March 10, 2014

**Re: SCA Contemporary Art, 816 Tijeras, Traffic Circulation Layout**  
**Architect's / Engineer's Stamp Not Stamped (J14-D114)**

Based upon the information provided in your submittal received 3-7-14, the above referenced plan cannot be approved for Building Permit until the following comments are addressed:

date
3-7-14
sheet
A001

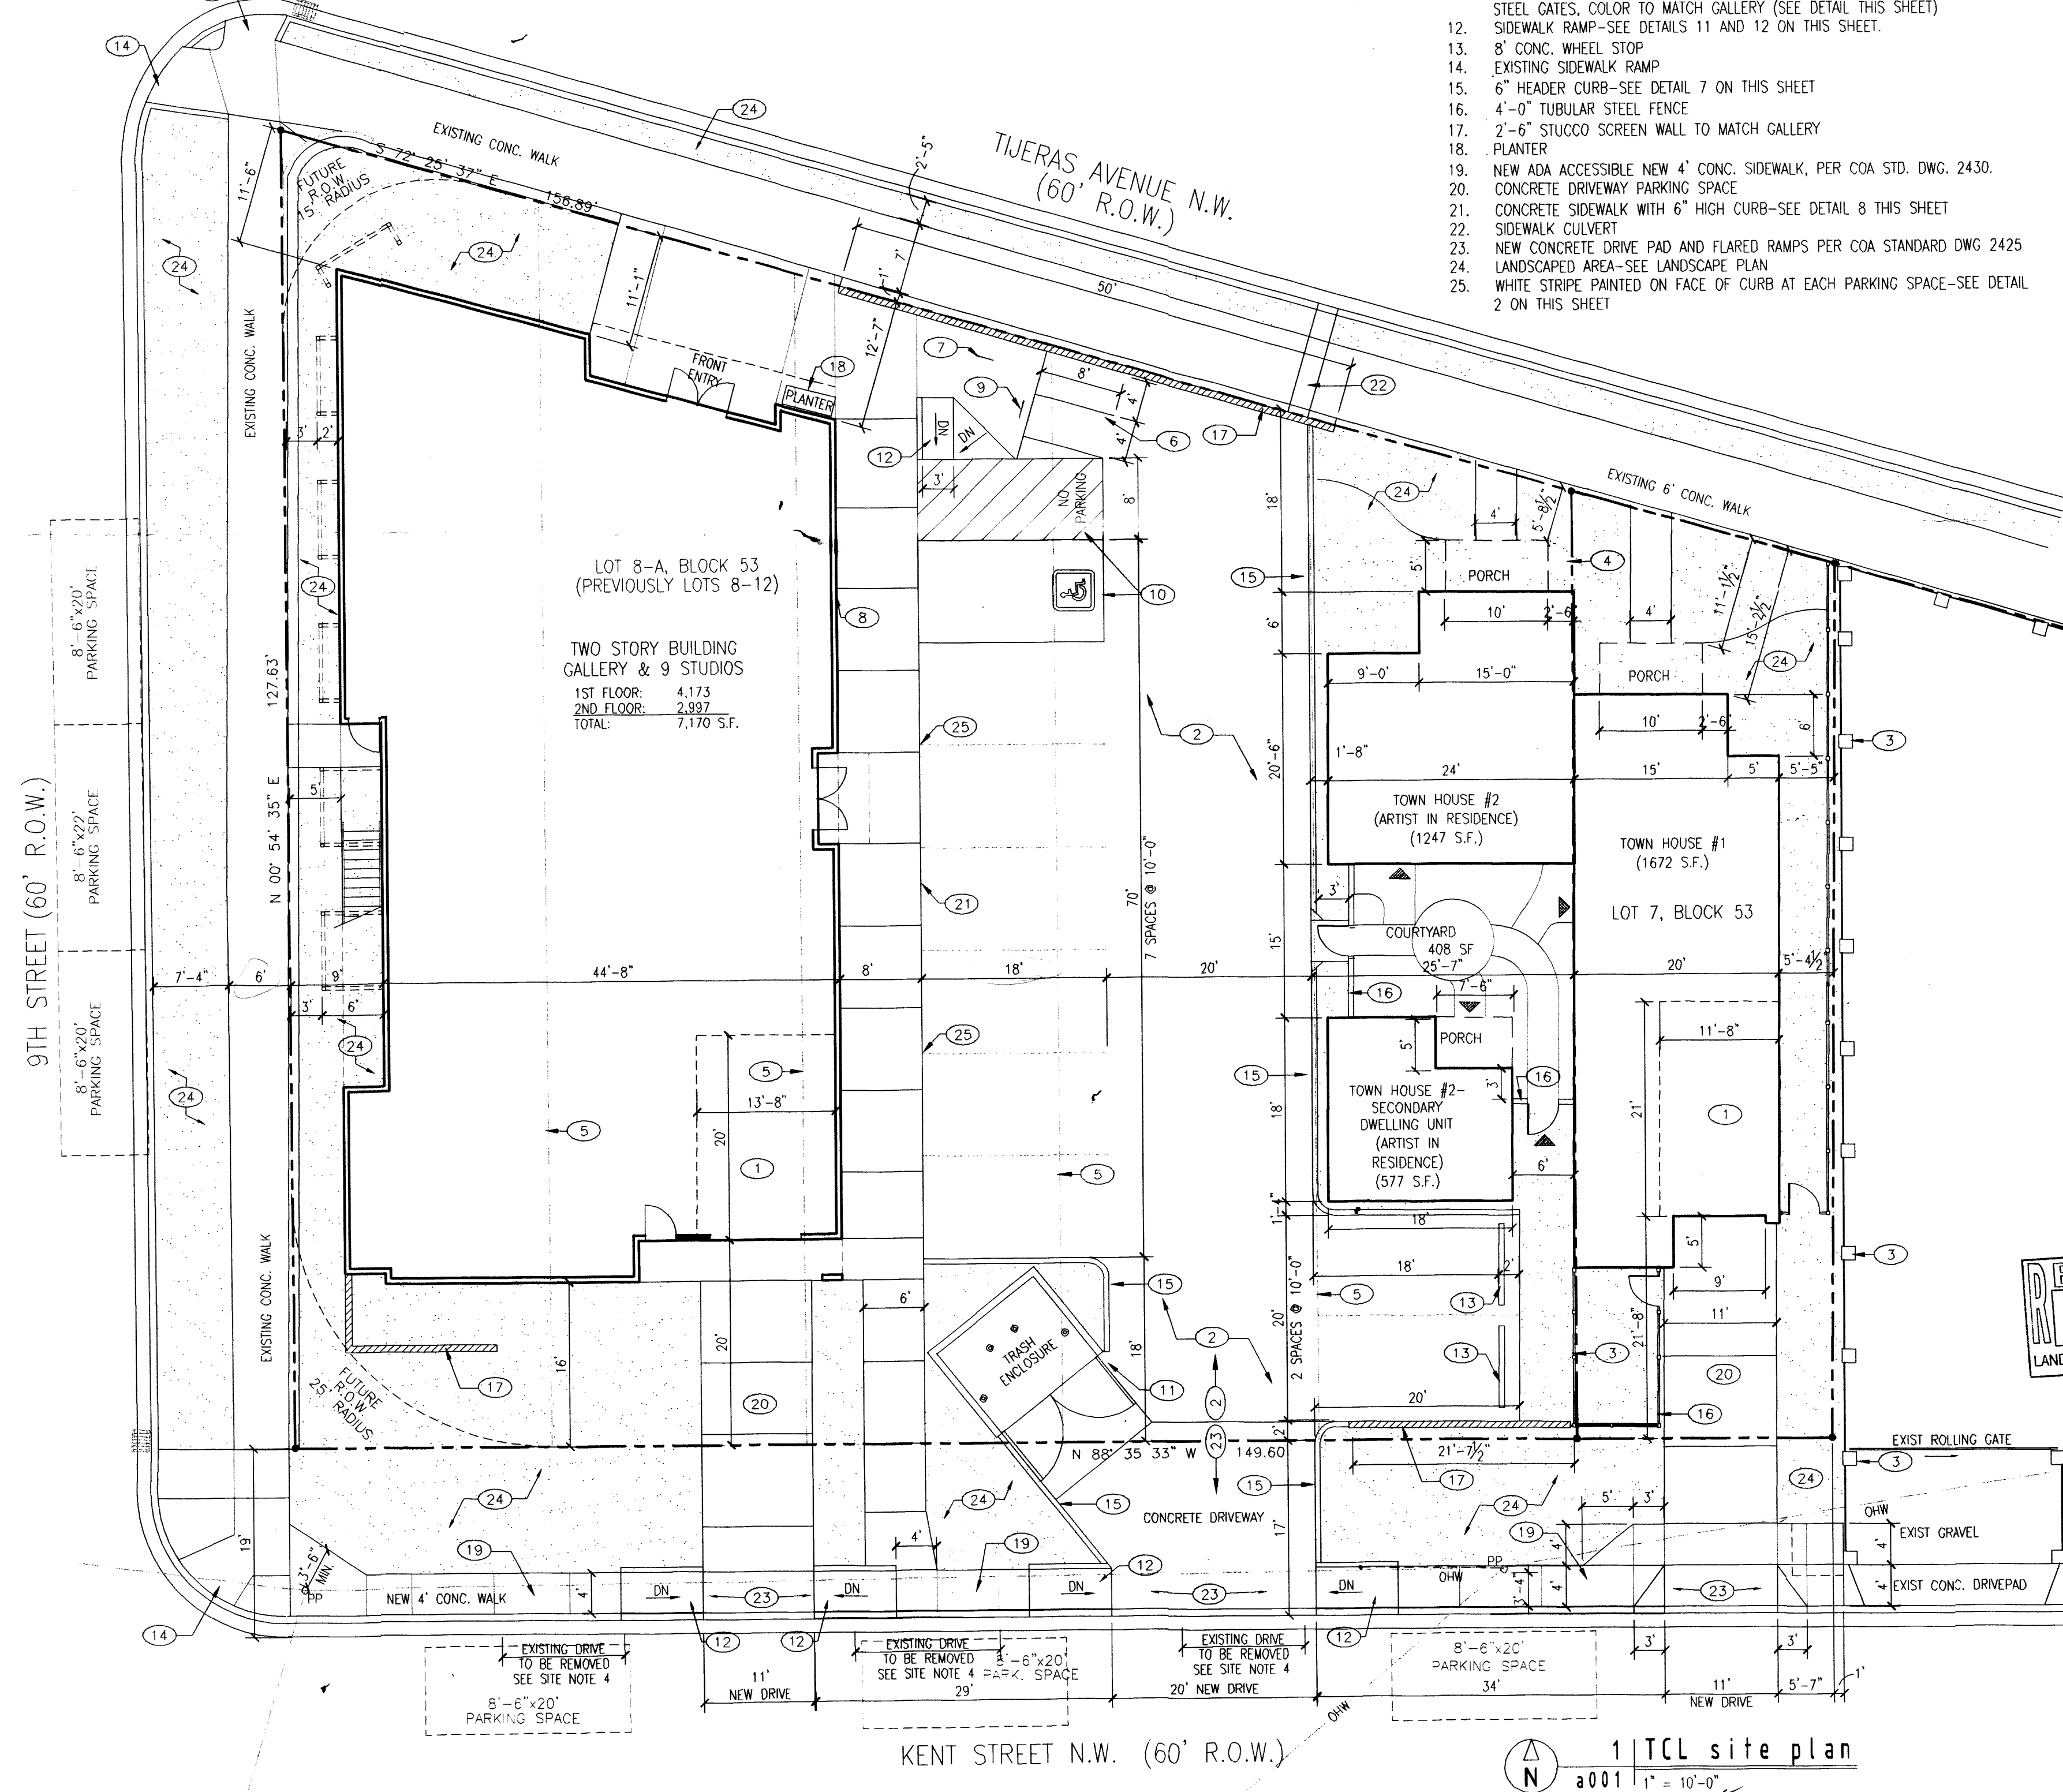
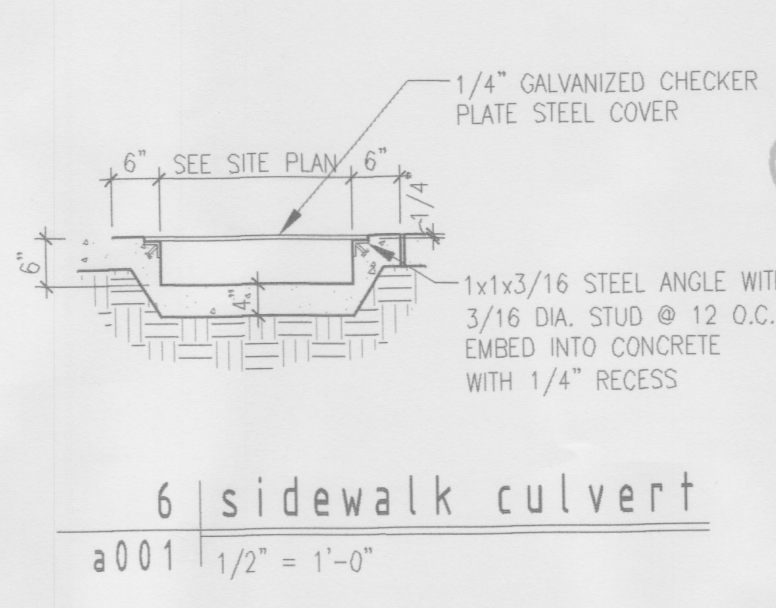
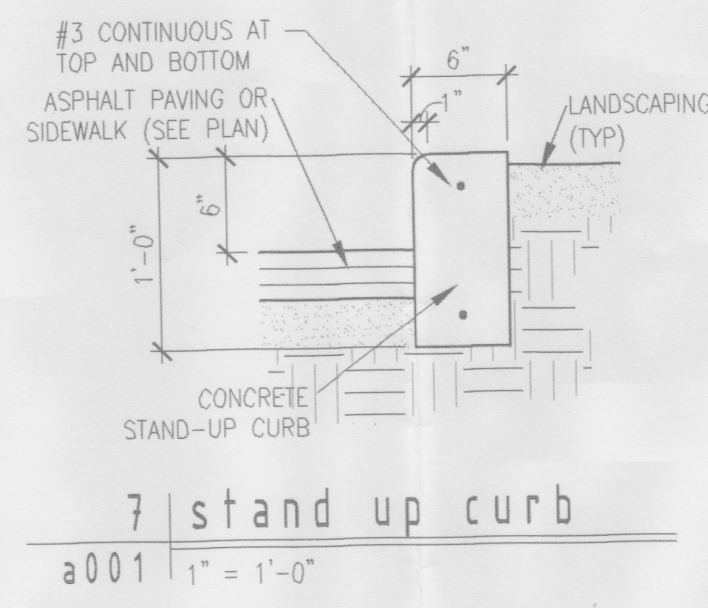
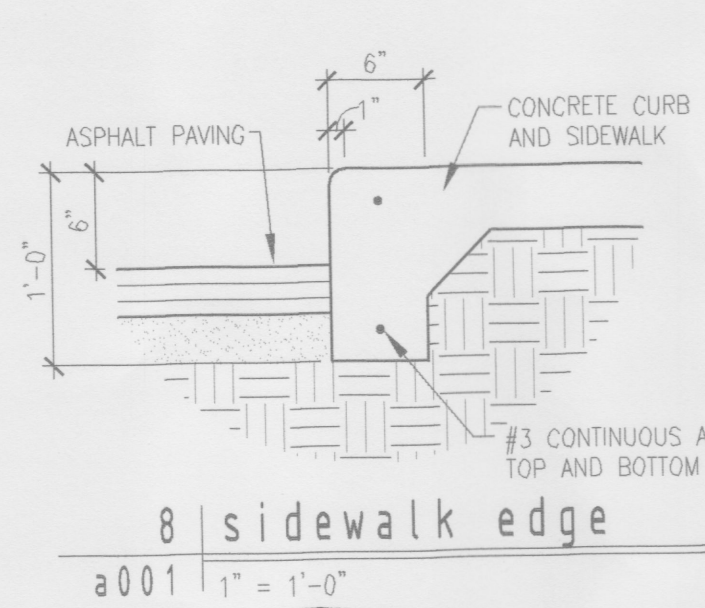
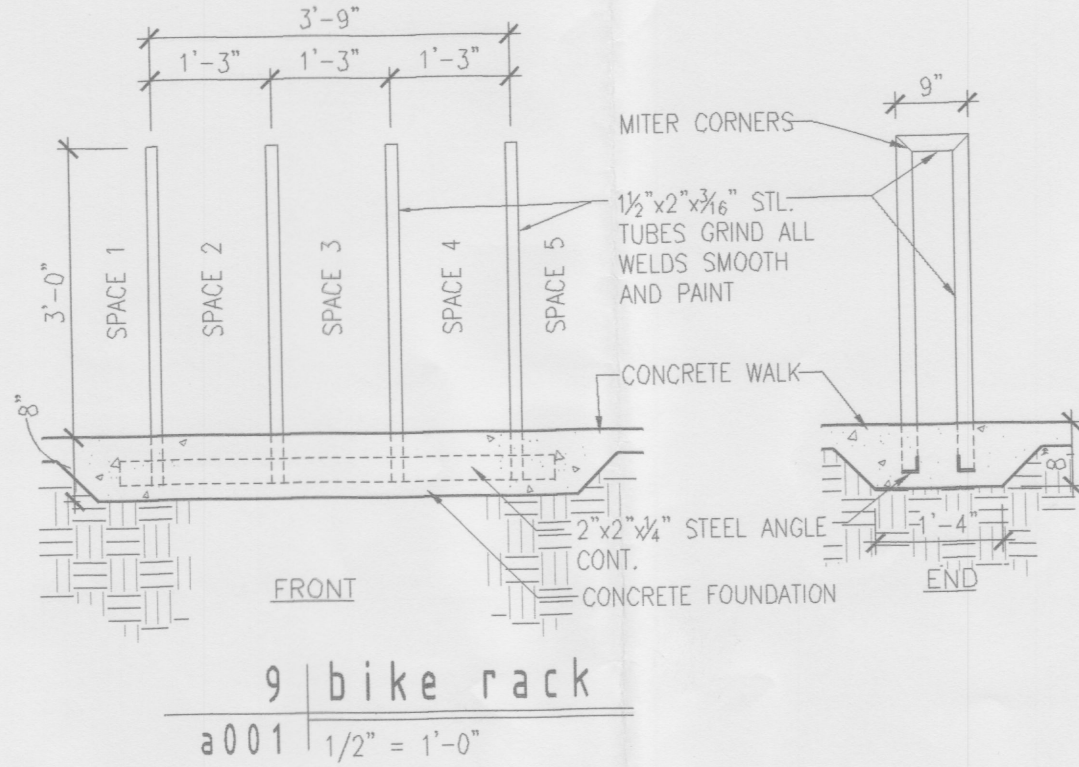
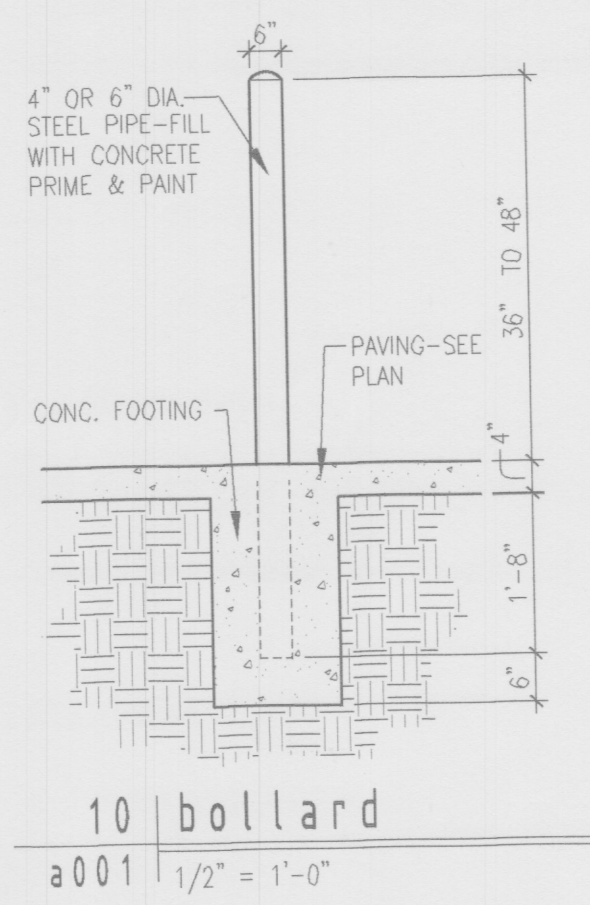
1. Please list the width and length for all parking spaces including garage spaces and driveway parking spaces.
2. Please show the location of the nearest driveway on the adjacent lot.

3. An ADA accessible 5 ft minimum landing run along sidewalk must be provided between proposed drive pad and existing. Please show.
4. Please show a vicinity map.

5. List the number of parking spaces required by the zoning code as well as the proposed number of parking spaces. What was provided is not clear.
6. Define width of the existing sidewalk on 9<sup>th</sup> St and Kent.

7. Abandon curb cuts must be replaced with sidewalk and curb & gutter. A build note must be provided referring to the appropriate City Standard (#2430 and #2415).

8. The development of this site must be in compliance with current DPM and ADA standards and regulations.
9. Per the DPM, a 6 ft. wide ADA accessible pedestrian pathway is required from the public sidewalk to the building entrances. Please clearly show this pathway and provide details. There appears to be an overlap between the proposed sidewalk/drivepad ramp and the 6 ft pedestrian path to the building.

10. Label applicable city standard at proposed drivepads. (i.e. COA STD DWG #2425 Sec D-D)
11. Show a detail of the wheelchair ramps located at the proposed driveway, or refer to the appropriate city standard.

12. The traffic circulation layout must be stamped, signed, and dated by an engineer or architect licensed in the state of New Mexico.
13. On-Street parking Allowance to fulfill zoning's parking requirement must be requested and approved by the Traffic Engineer, Kristal Metro prior to
